<b>Application Ref:</b>	3/2021/0322	 <div>Ribble Valley Borough Council</div> <div><a href="http://www.ribblevalley.gov.uk">www.ribblevalley.gov.uk</a></div>	
<b>Date Inspected:</b>	N/A		
<b>Officer:</b>	BT		
<b>DELEGATED ITEM FILE REPORT:</b>		<b>Decision</b>	Approval

<b>Development Description:</b>	Lawful Development Certificate for existing shed (7m x 4m) in the rear garden.
<b>Site Address/Location:</b>	82 Mersey Street, Longridge. PR3 3RL

82 Mersey Street, PR3 3RL

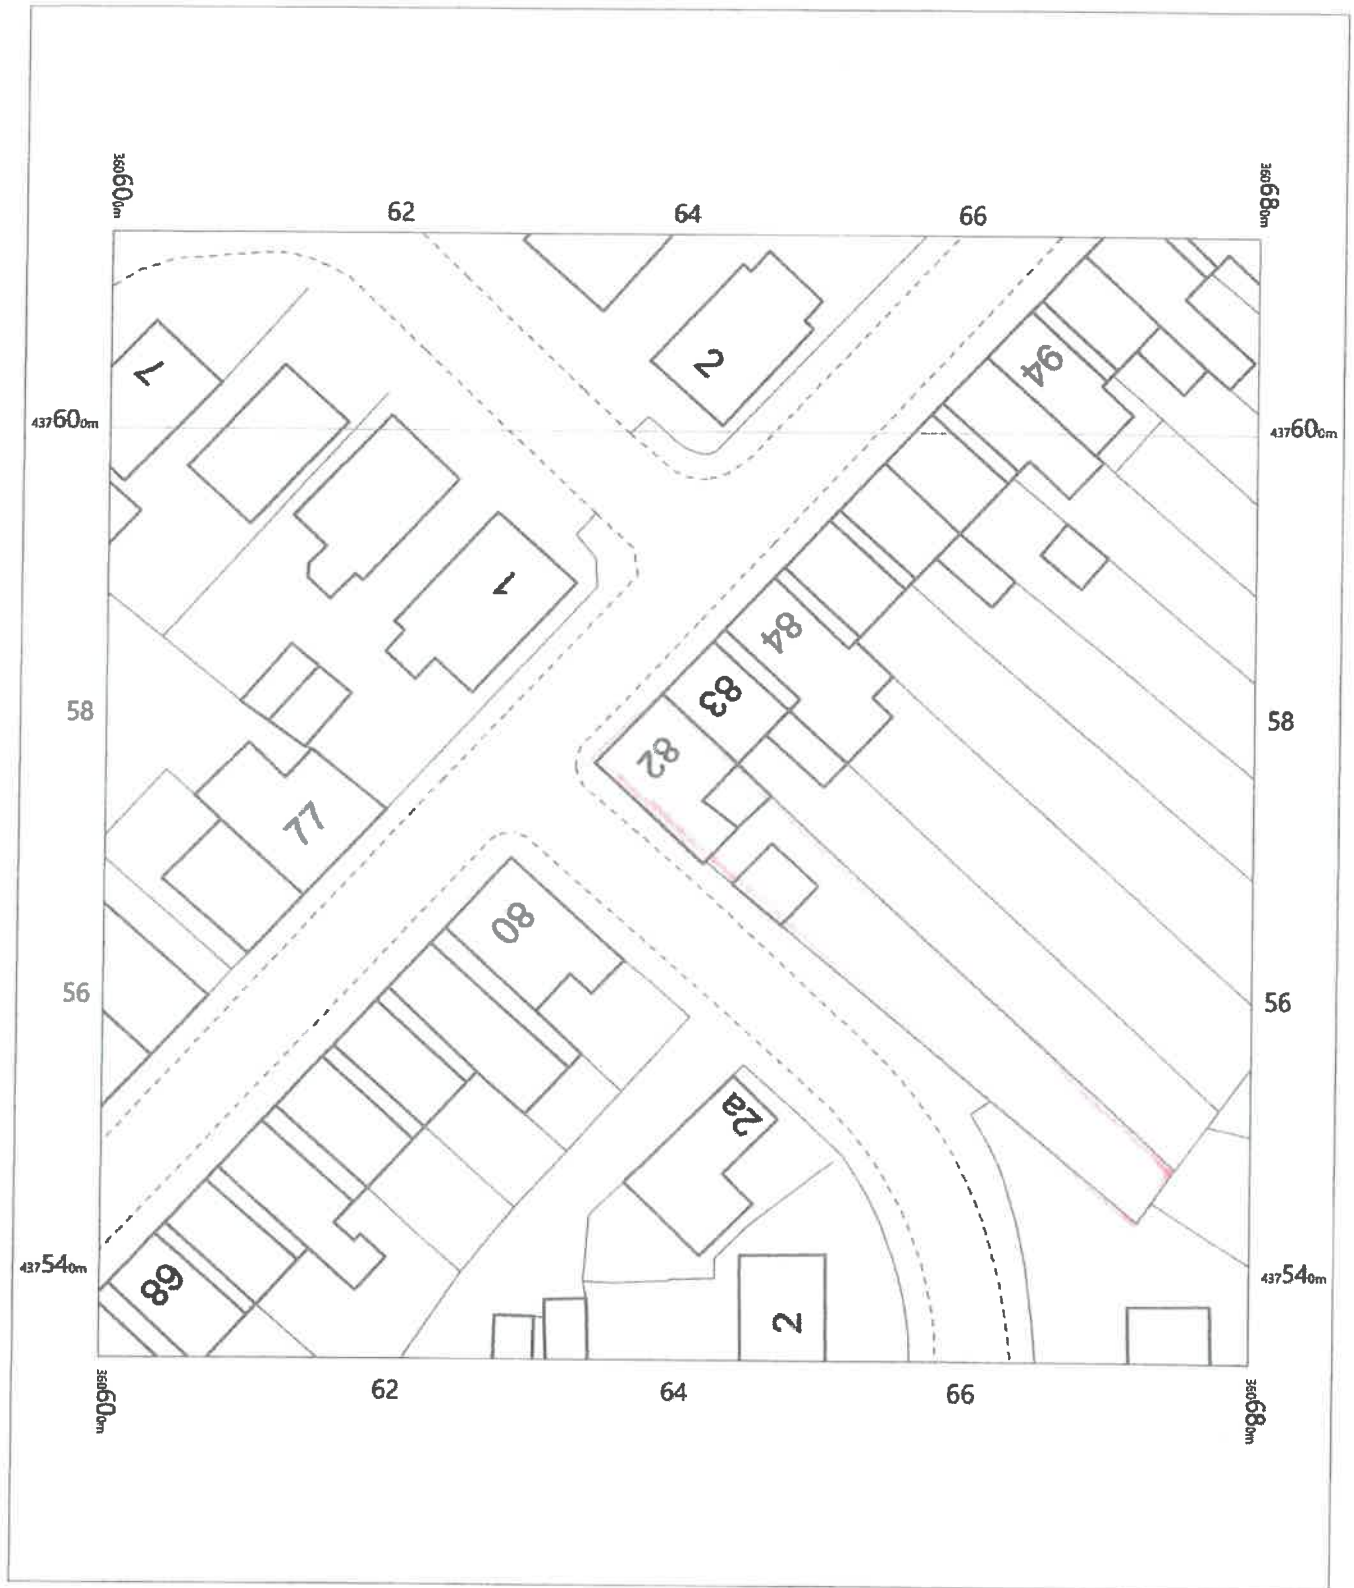
(b) the total area of ground covered by buildings, enclosures and containers within the curtilage (other than the original dwellinghouse) would exceed 50% of the total area of the curtilage (excluding the ground area of the original dwellinghouse);

**The existing shed does not exceed 50% of the total area of curtilage of the property.**

(c) any part of the building, enclosure, pool or container would be situated on land forward of a wall forming the principal elevation of the original dwellinghouse;

**The existing shed is not situated on land forward of a wall forming the principal elevation of the original dwellinghouse.**

**The existing shed is situated within 2 metres of the boundary of the curtilage of the dwellinghouse and has a roof height of 2.4 metres.**

**The height of the eaves of the existing shed is 2 metres.**
